**Item No.**                      **Report of the Head of Development Management and Building Control**

**Address:**                      37 EDGAR ROAD YIEWSLEY

**Development:**                Erection of a rear dormer and conversion of roof from hip to gable end.  
Change of use to use from residential property (Class C3) to an 7 bedroom HMO (Sui Generis).

**LBH Ref Nos:**                **79256/APP/2025/387**

PROPOSED FLOOR PLANS

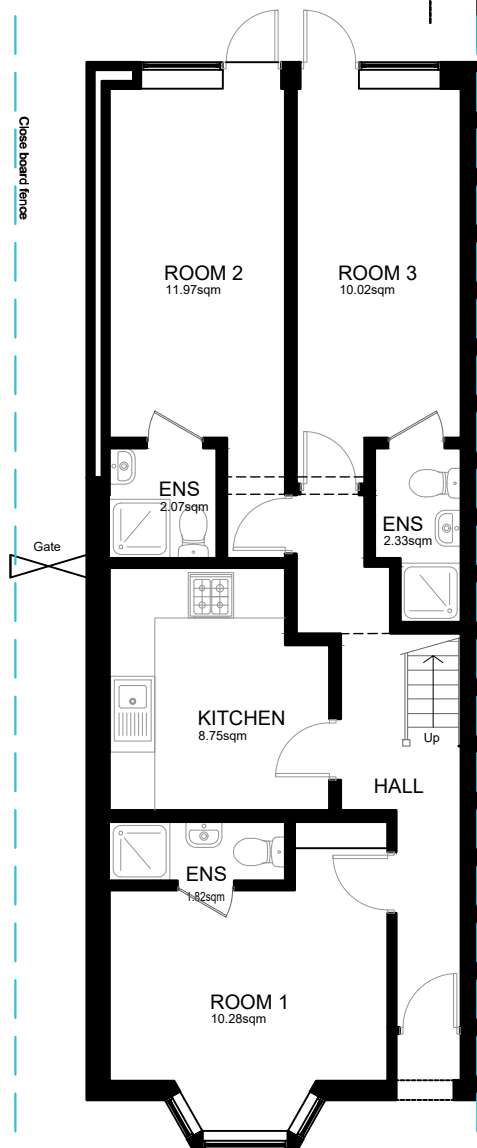
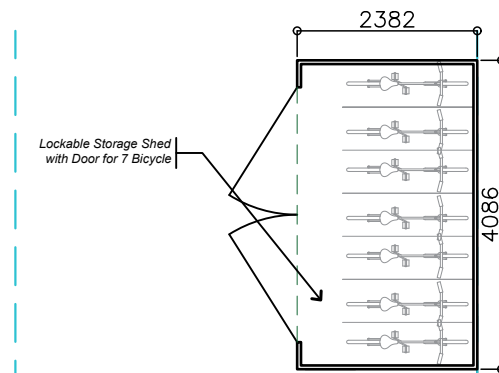
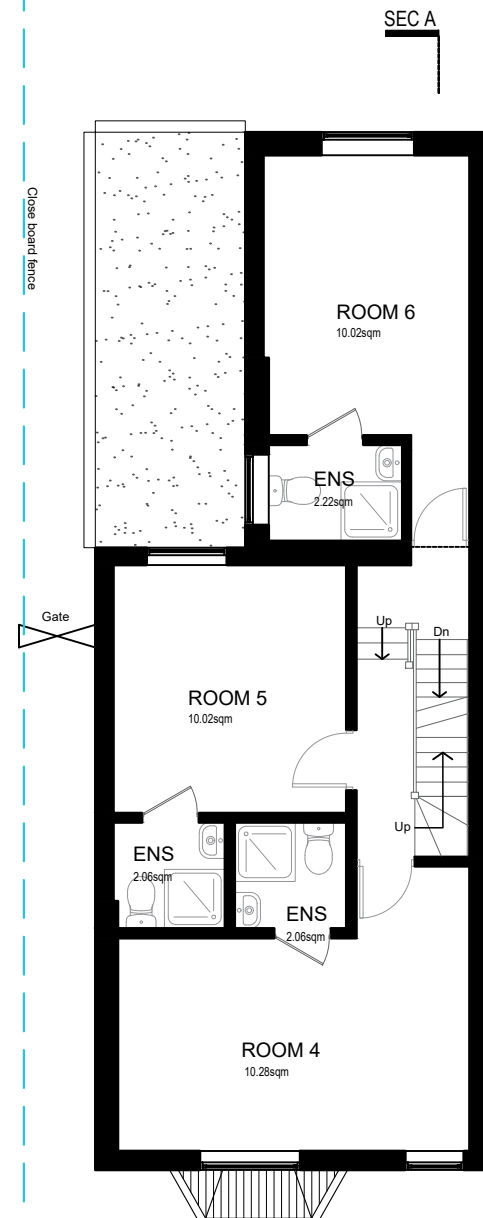
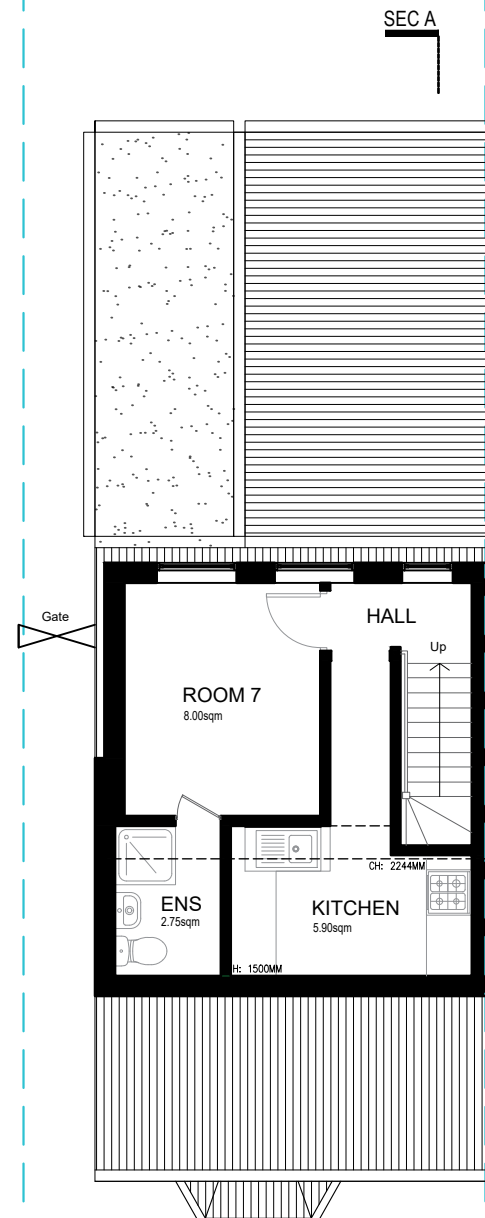
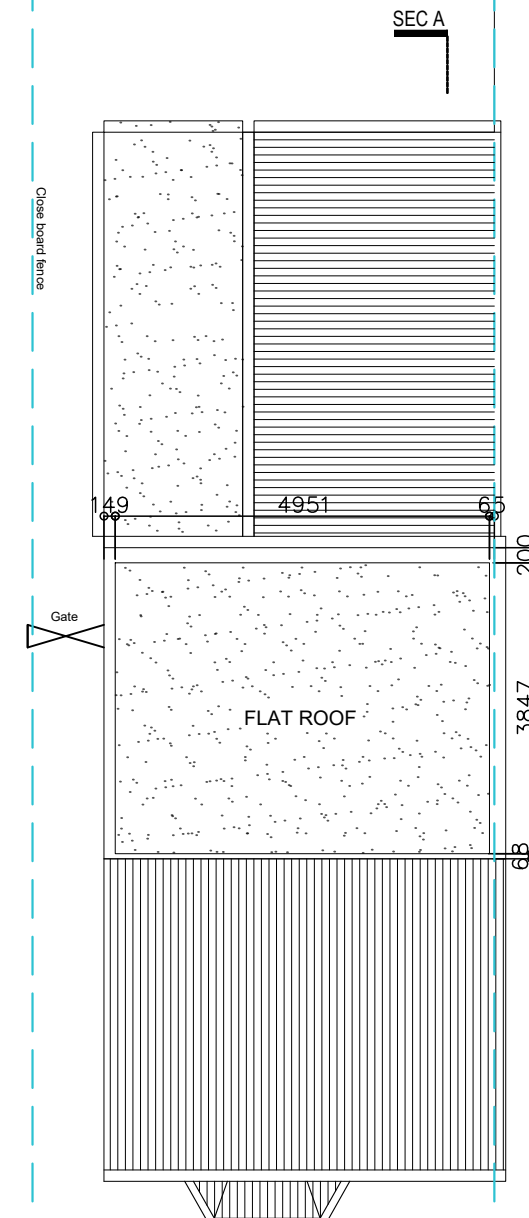
Room 1 - Double 12.1 sq.m  
Room 2 - Double 14.04 sq.m  
Room 3 - Double 12.35 sq.m  
Room 4 - Double 12.34 sq.m  
Room 5 - Double 12.08 sq.m  
Room 6 - Double 12.24 sq.m  
Room 7 - Studio 21.5 sq.m

All of the bedroom sizes are of a suitable size. It is noted that the loft space comprises its own kitchen and would be viewed as a self-contained studio flat.

Whilst the HMO is provided with a kitchen space, this sole communal facility is unlikely to be sufficient to accommodate the level of persons envisaged to occupy the property. Notably there are no utility/laundry rooms or living rooms for use by occupiers.

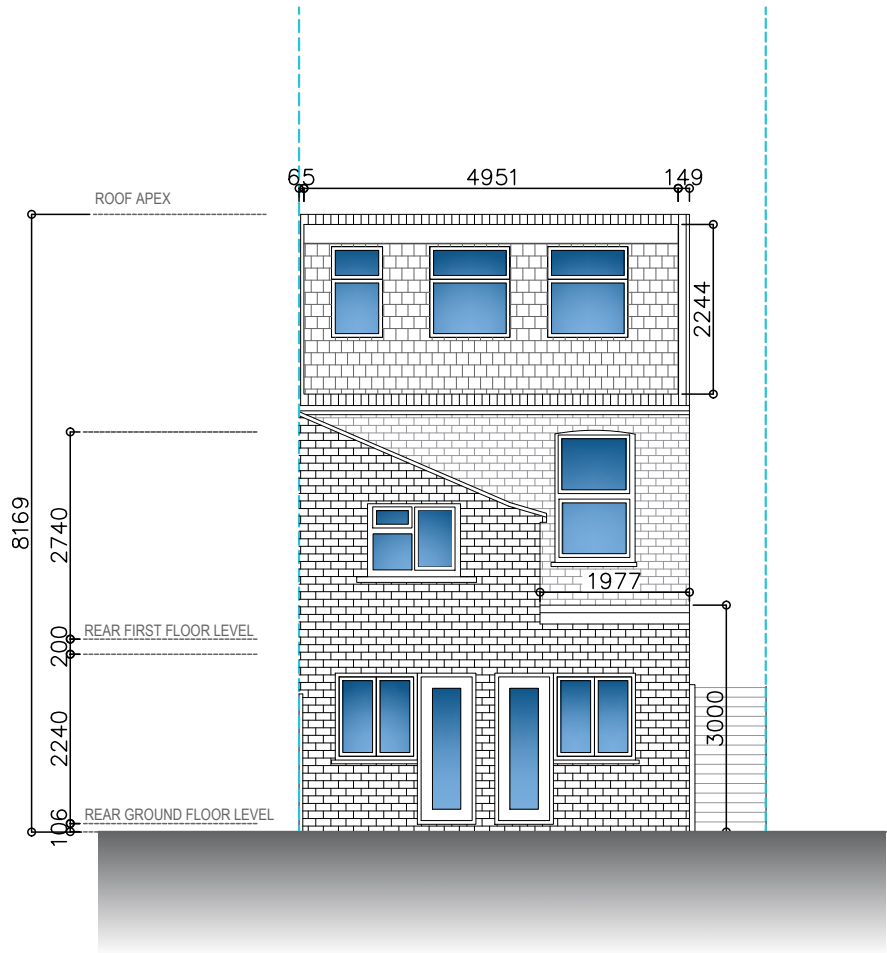
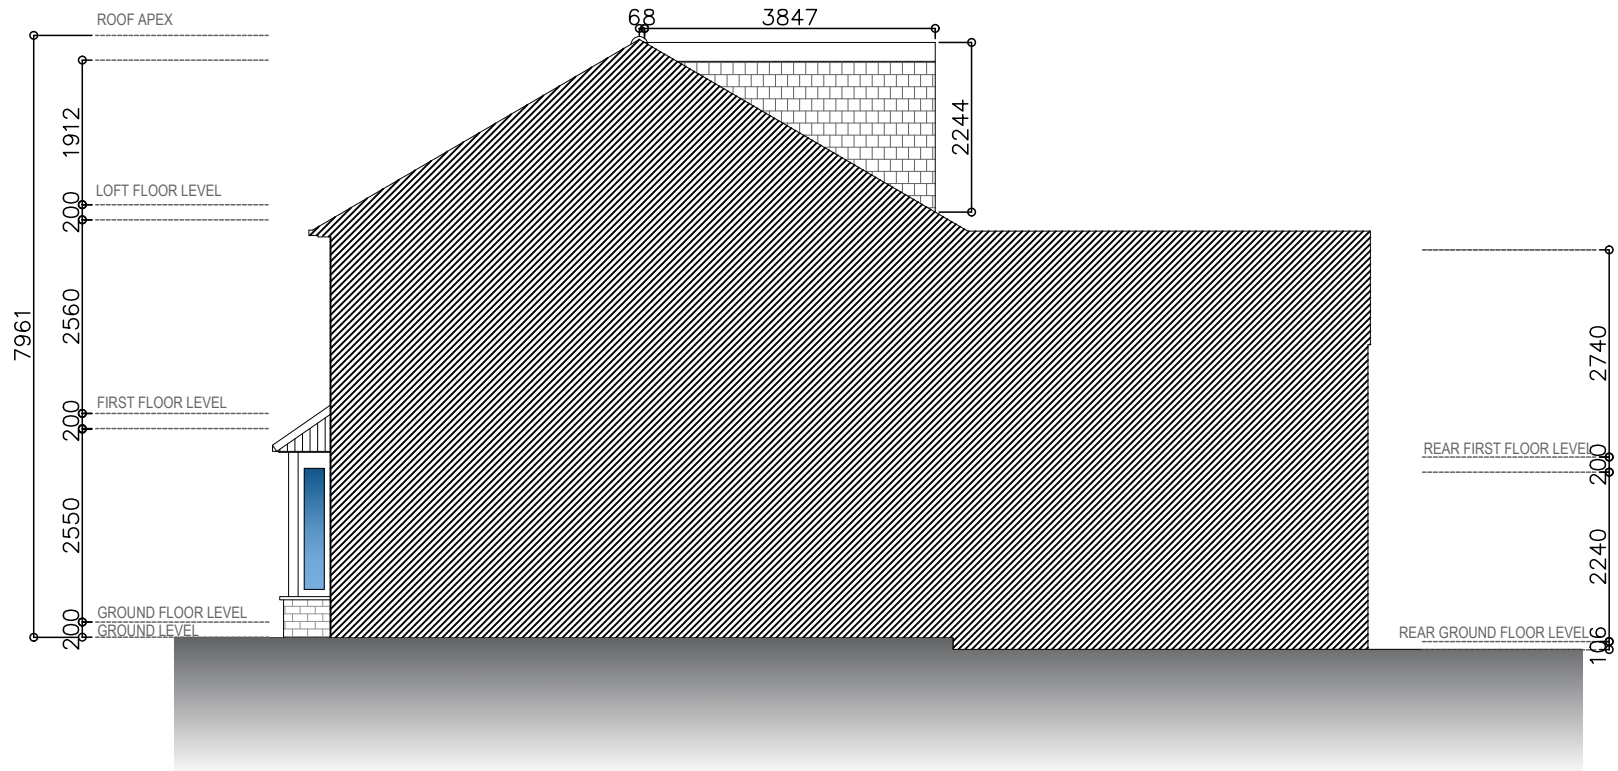
The roof materials do not match that of the existing dwelling, however it is noted that there are a variety of roof finishes on Edgar Road. Whilst matching materials would have been preferred, the site is not subject to any heritage designations and a refusal on a different roof tile being used would be difficult to sustain.

Whilst the rear dormer exceeds two thirds the width of the roof slope, there is a presence of similar loft extensions in the street scene of Edgar Road. The roof extensions would not appear as insubordinate and incongruous additions in the street scene and as such there would not be any material harm to the character and appearance of the area that would warrant refusal.
